*** REVISE***

Site Development Plan Project Statement and Justification

Project: Proposed Chick-fil-A Drive-Thru Restaurant

Location: SEC of Powers Blvd & Palmer Park, Colorado Springs, CO 80951

SHEET SITE PLAN

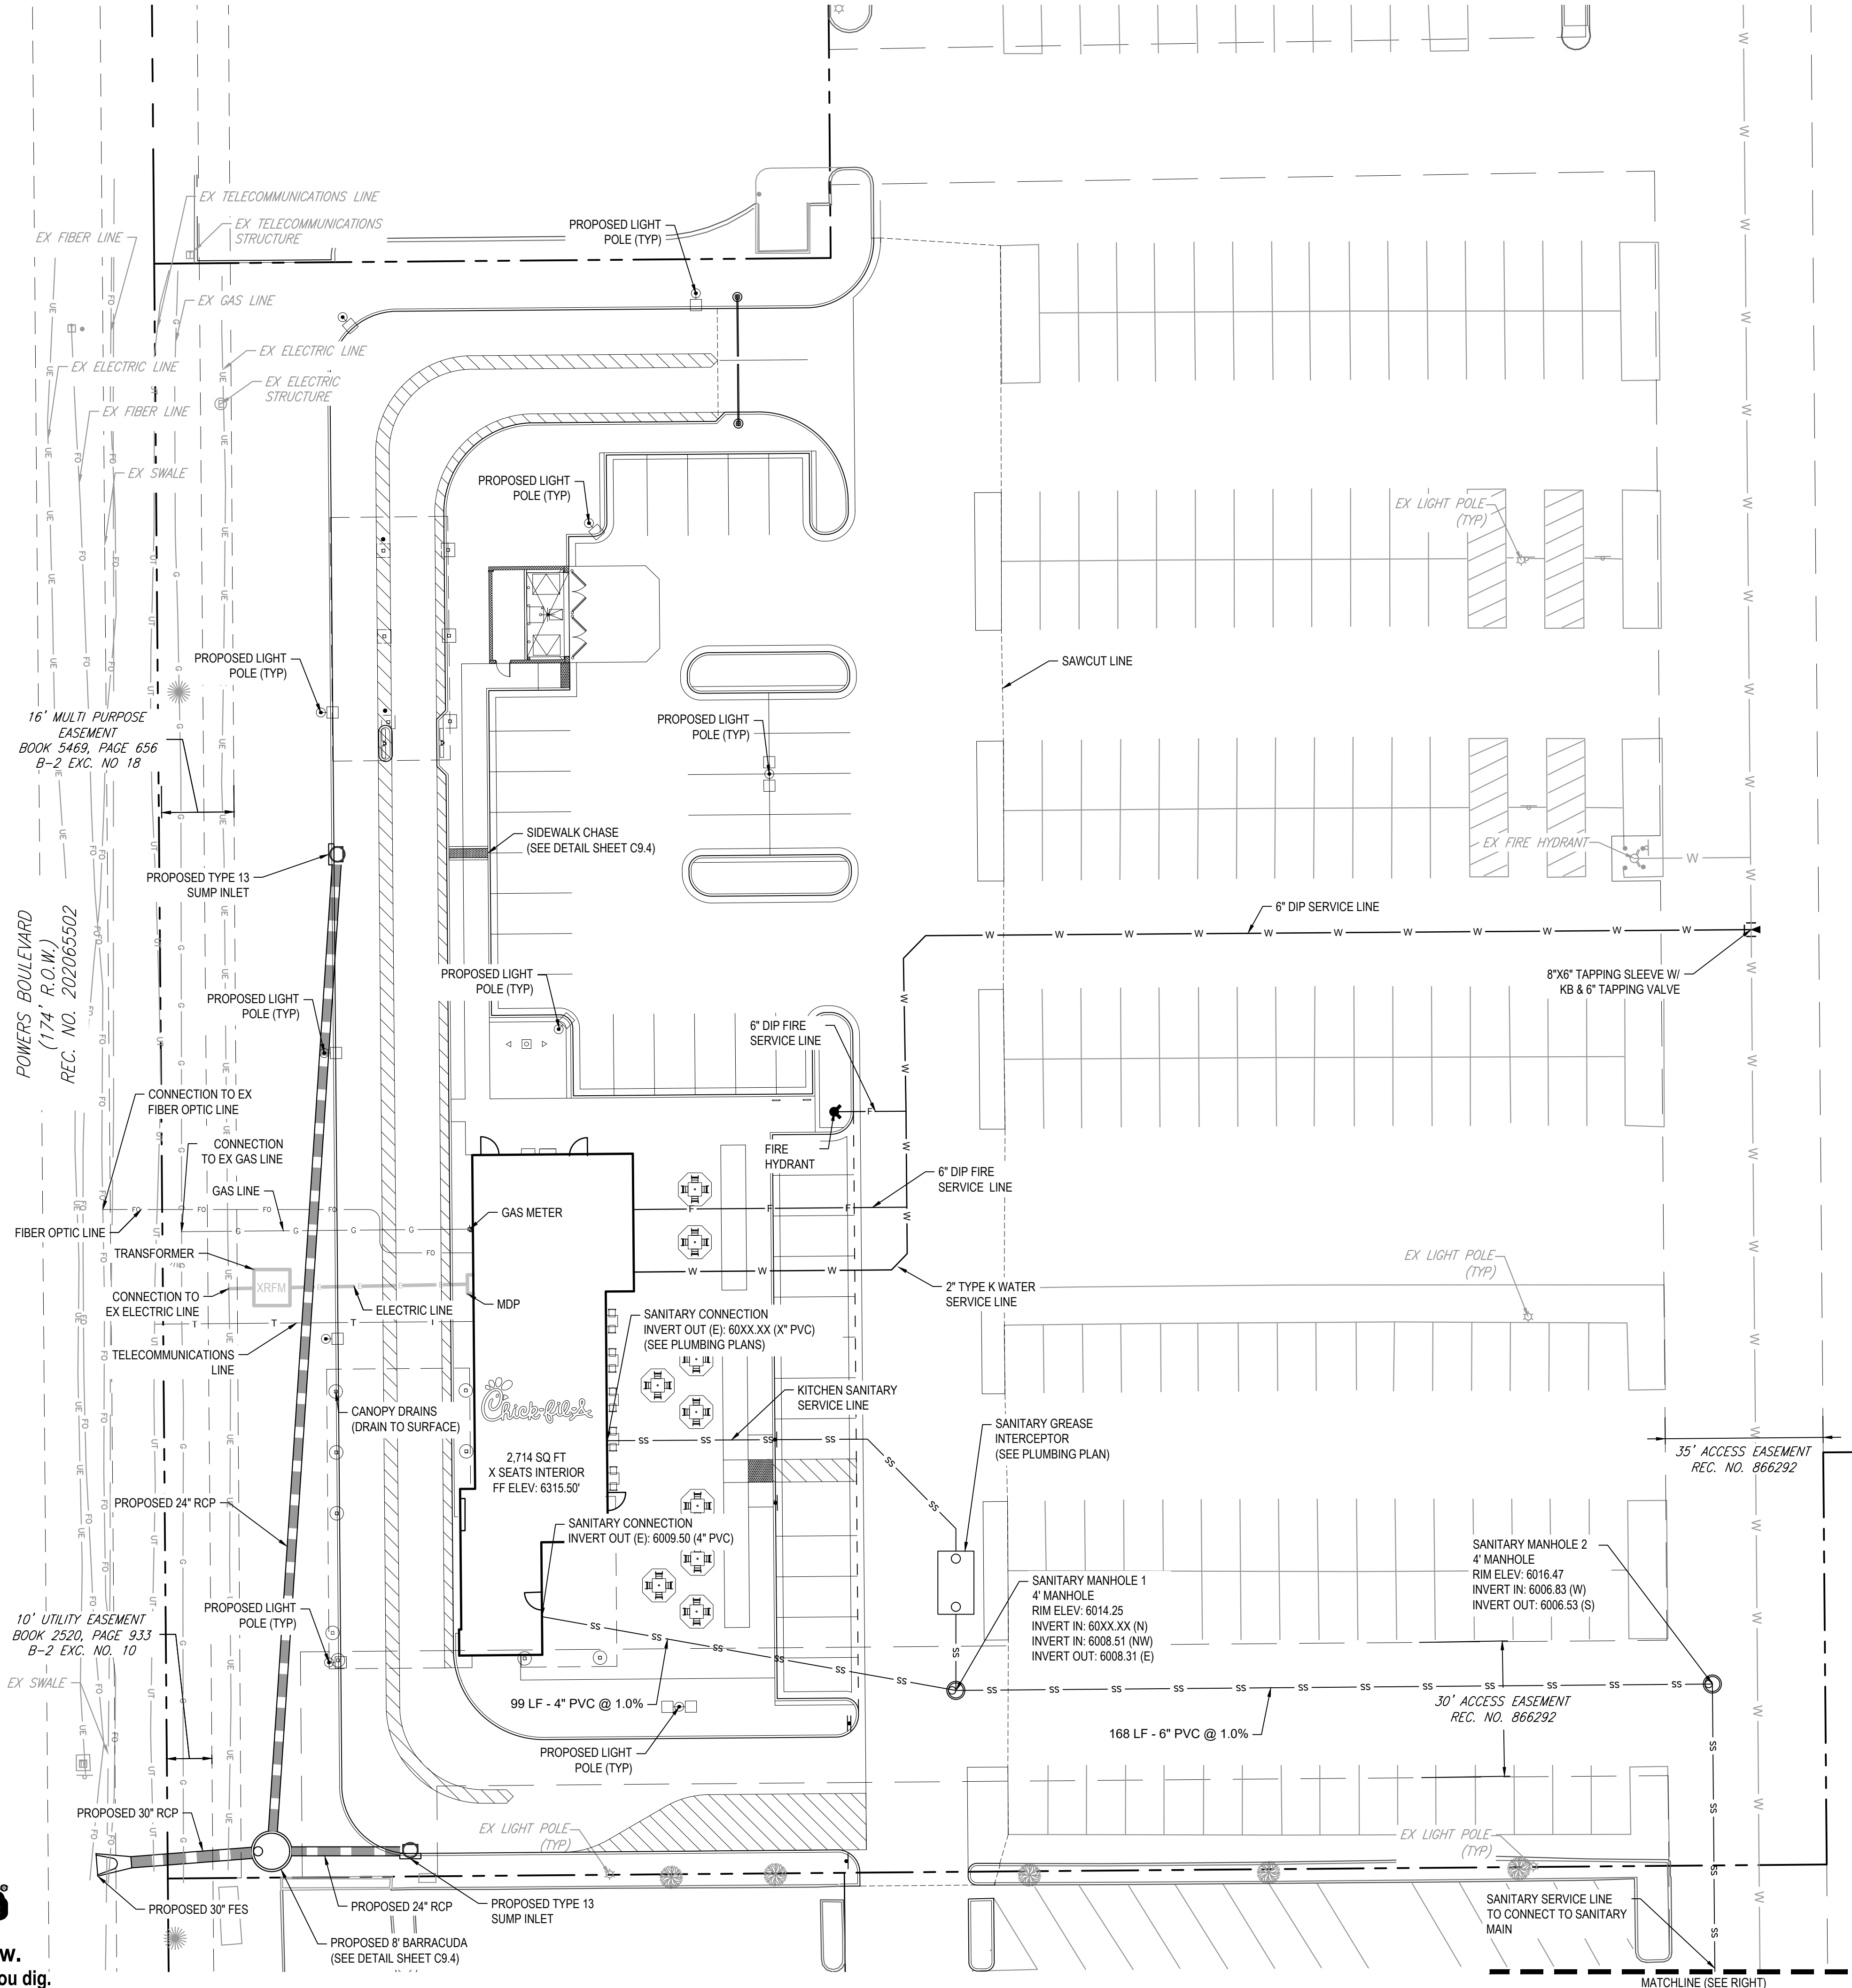
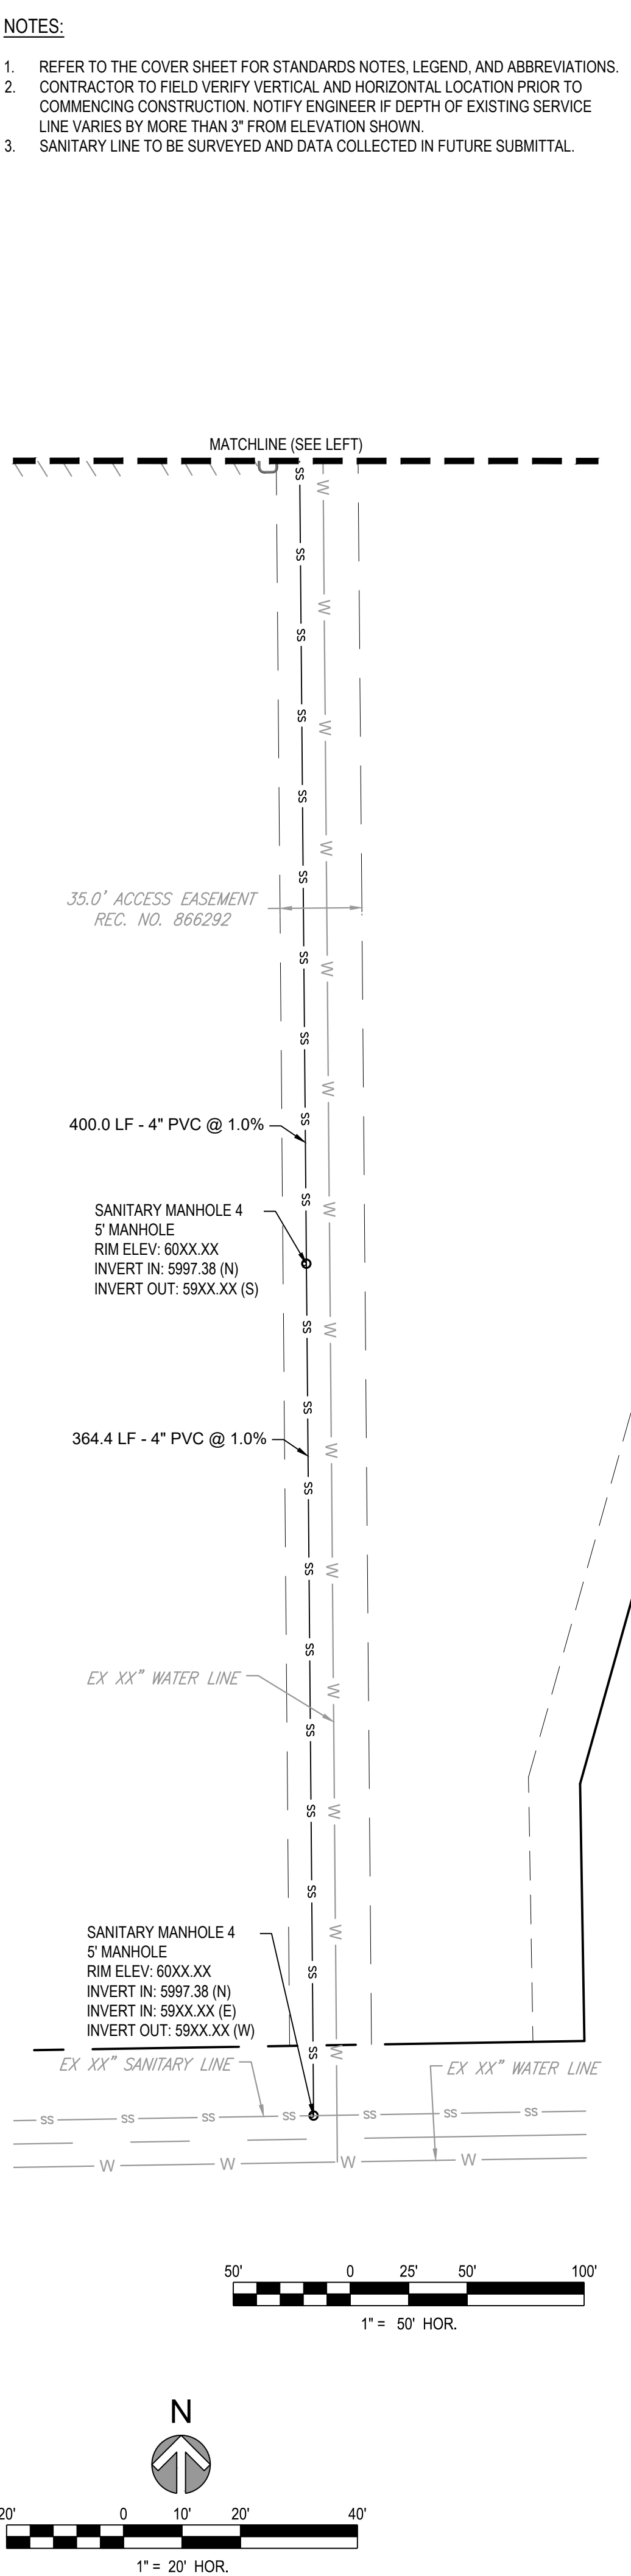
2962 is what shows on the site plan, please be consistent

discuss how many disabled parking spaces are proposed
